CITY OF ALBUQUERQUE

July 3, 2012

**Re: Balloon Fiesta Park Tribute Area, Grading and Drainage Plan
Engineer's Stamp Date -no stamp- (B17/D001)**

SIDEWALK CULVERT
WITH STEEL PLATE TOP

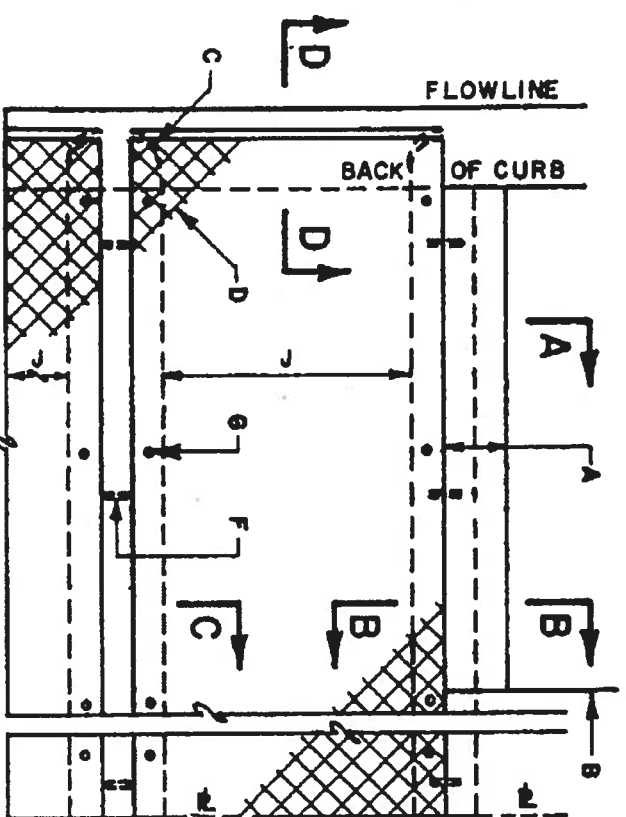
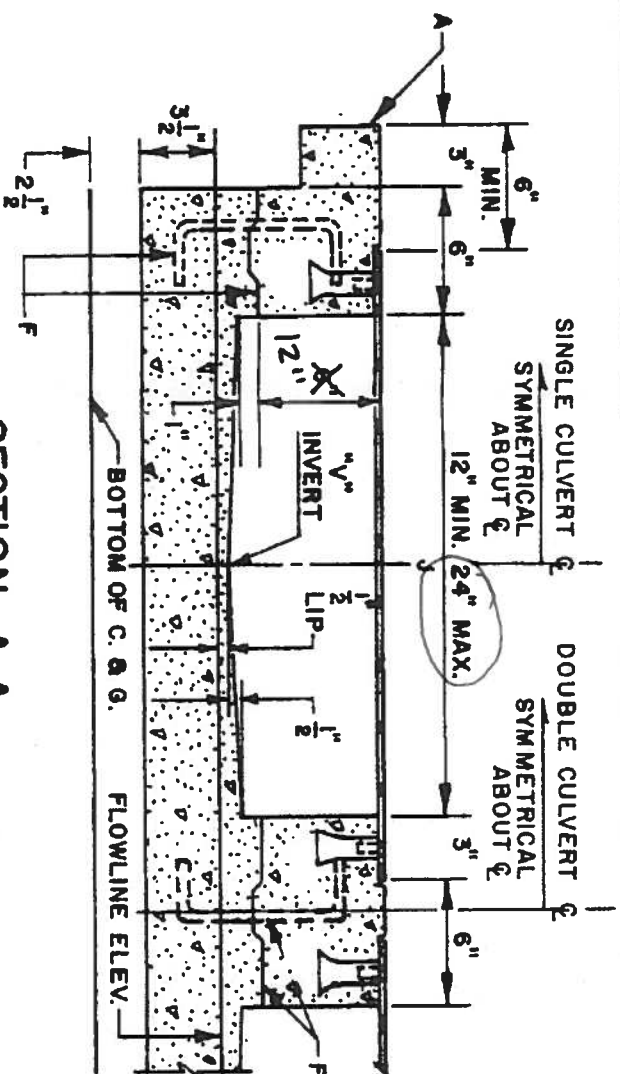
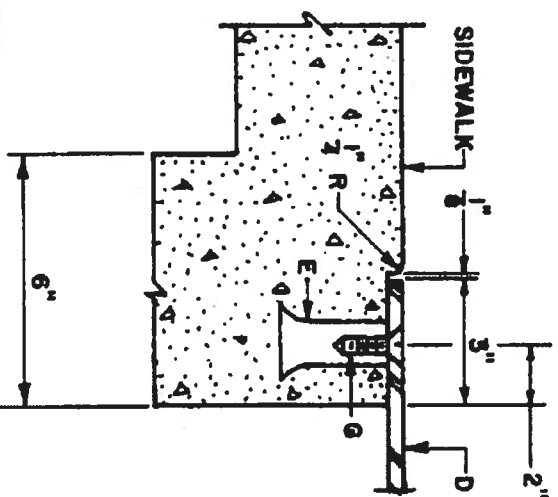
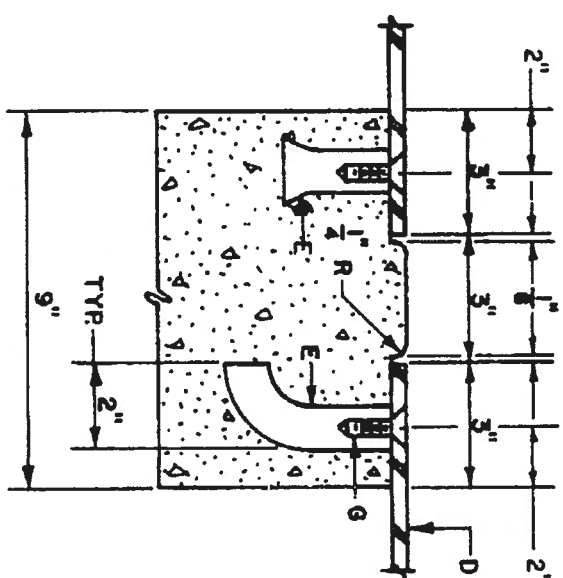
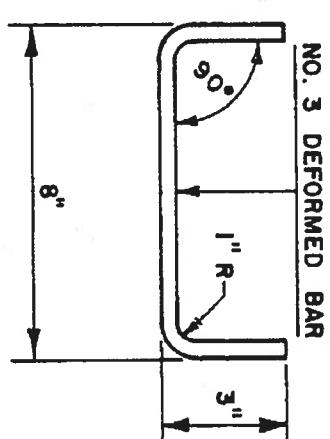
- The swale in the middle (main swale) of the site should drain under the sidewalk and bike path (?) and be hard-lined to the AMAFCA channel. AMAFCA may have additional criteria for this since the channel is AMAFCA's. Provide calculations for this drainage facility.

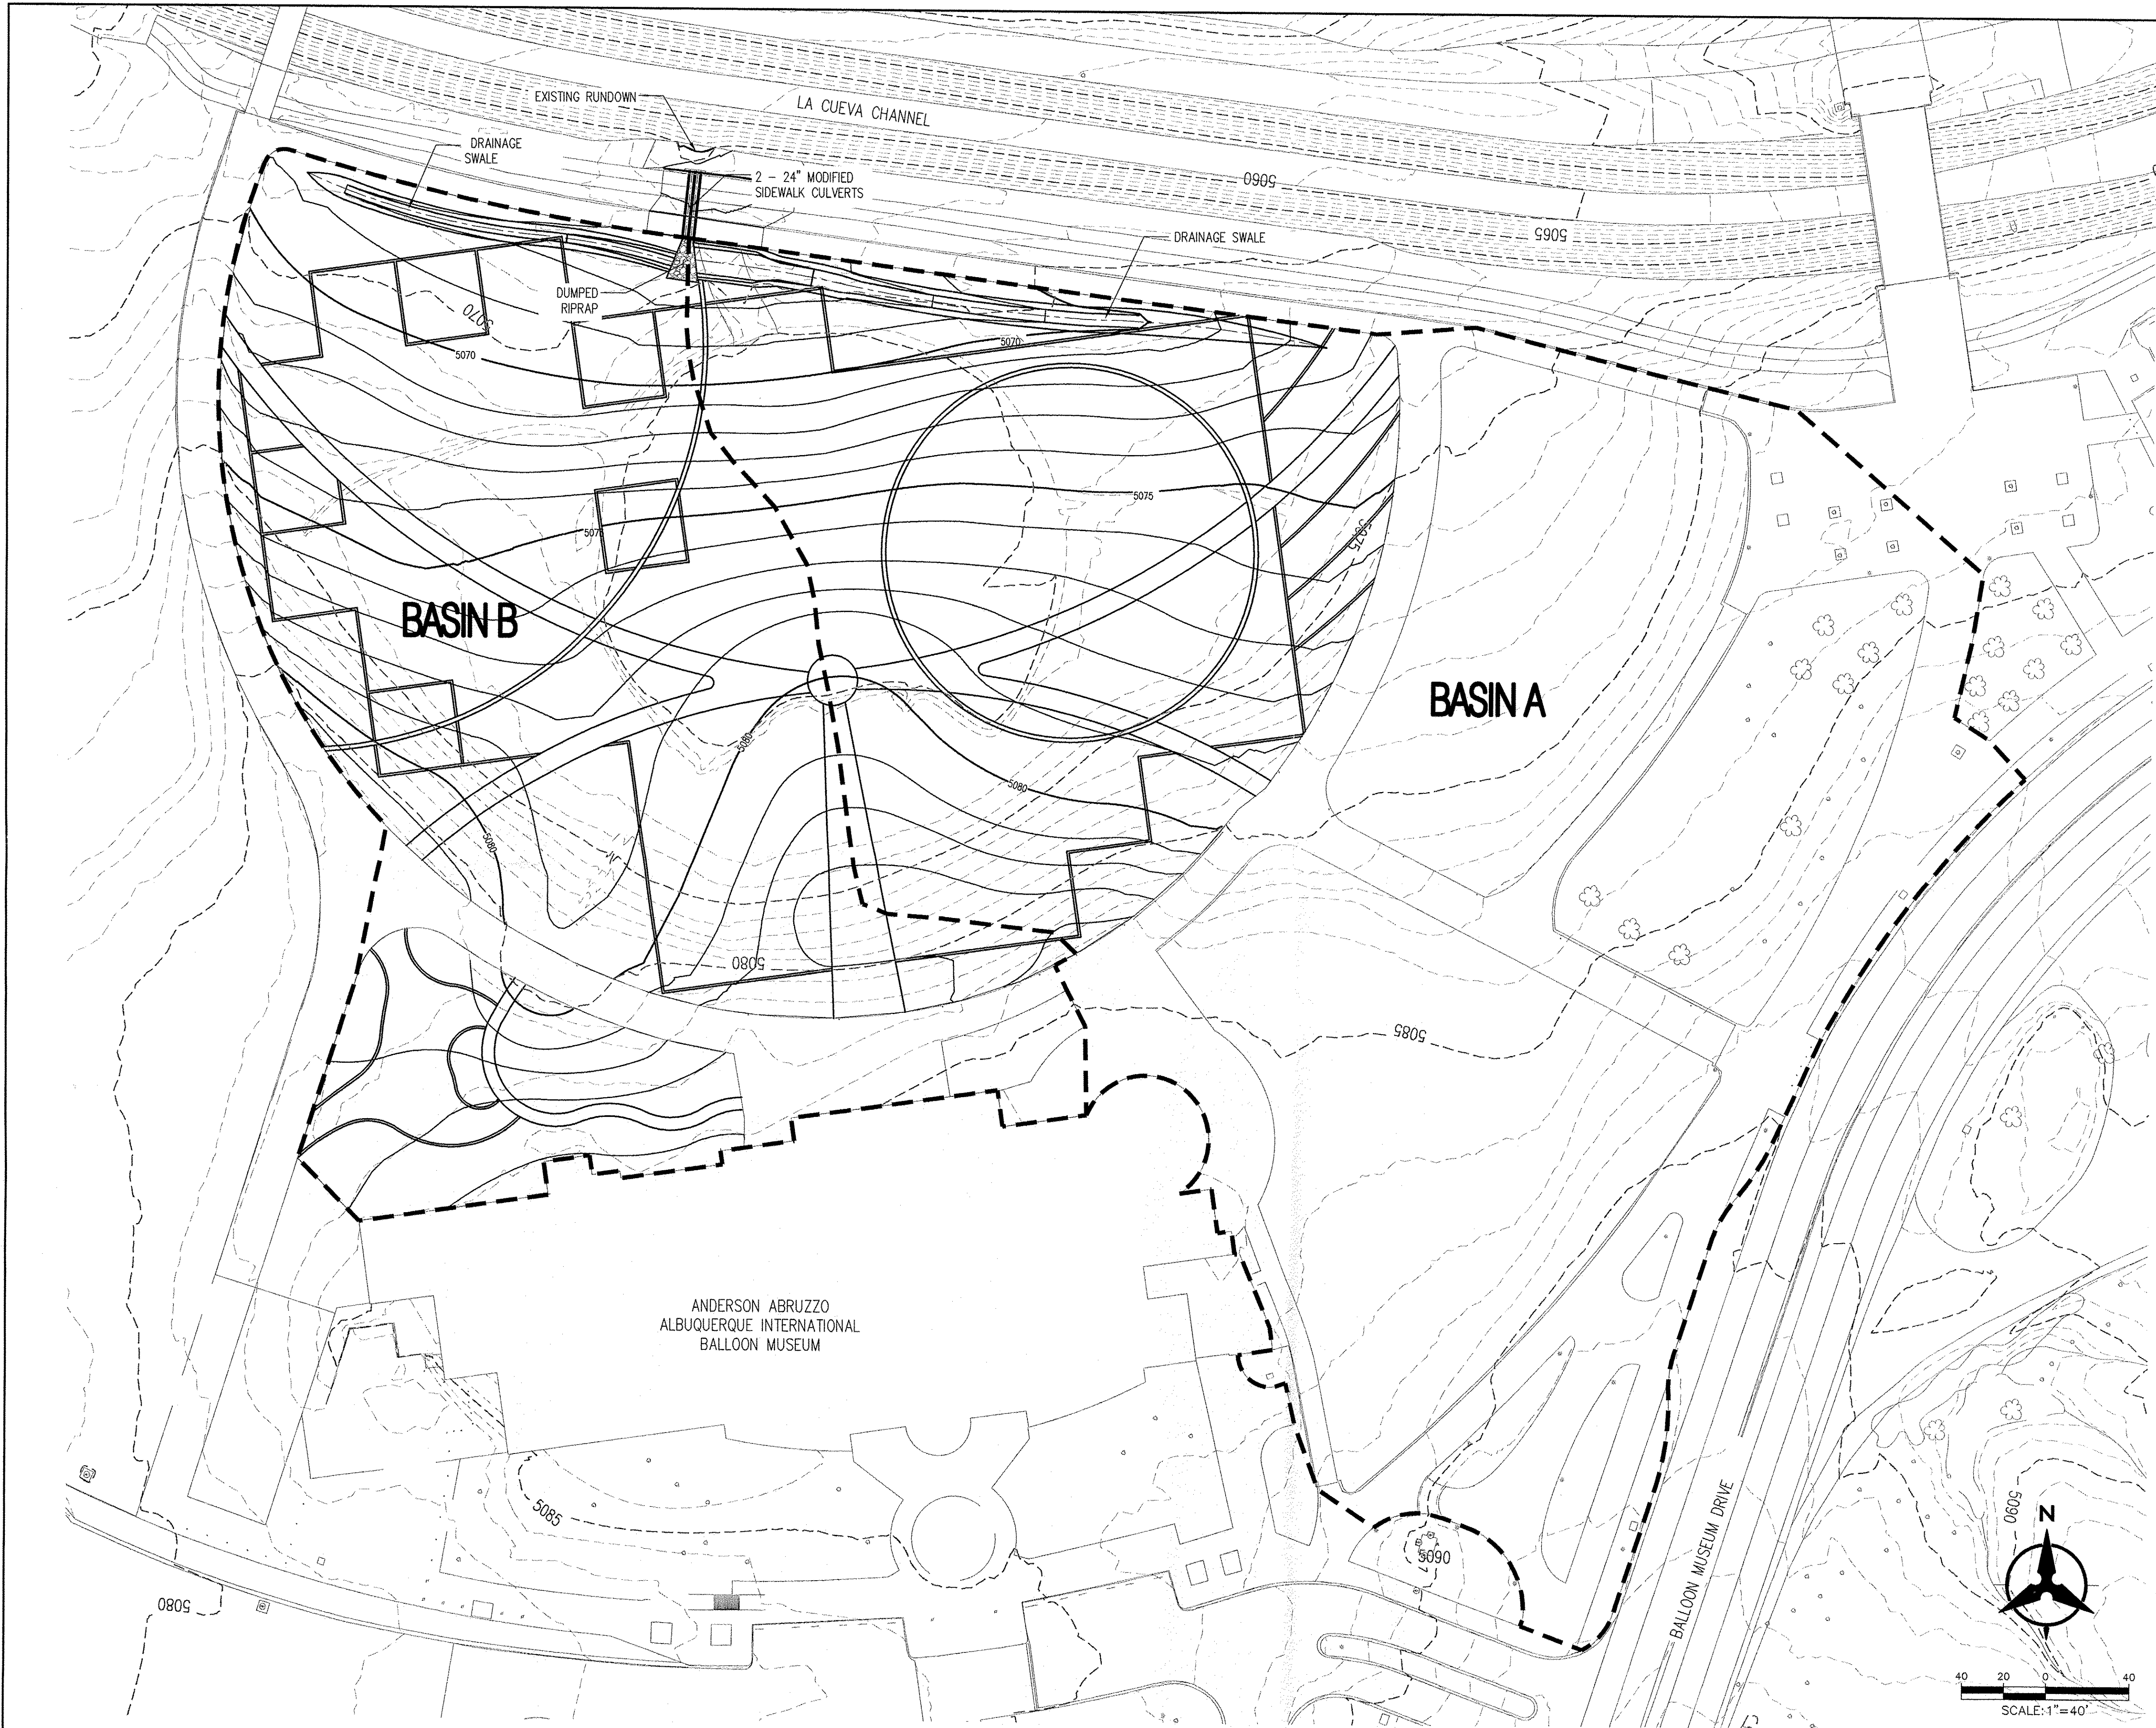
- Grading and drainage plans are to be stamped and signed by a Professional Engineer registered in the state of New Mexico.
- Basin A appears to be larger than what is proposed due to flows from south and east of the project area. Does the building drain north?

- AMAFCA approval is required.
- Provide a detail of the main swale similar to the 6' and 8' wide swales. *sw culv.*
- Why does the area between the drainage swales and the sidewalk drain over the sidewalk? This area could be graded to drain to the swale.

- Show the property line(s) on the grading and drainage plan. Is a portion of the sidewalk built in AMAFCA ROW?
- The plan would be easier to review if some key elevation points (swale inverts, channel inlet, etc...) were on the grading and drainage plan rather than in a points table on a different sheet.
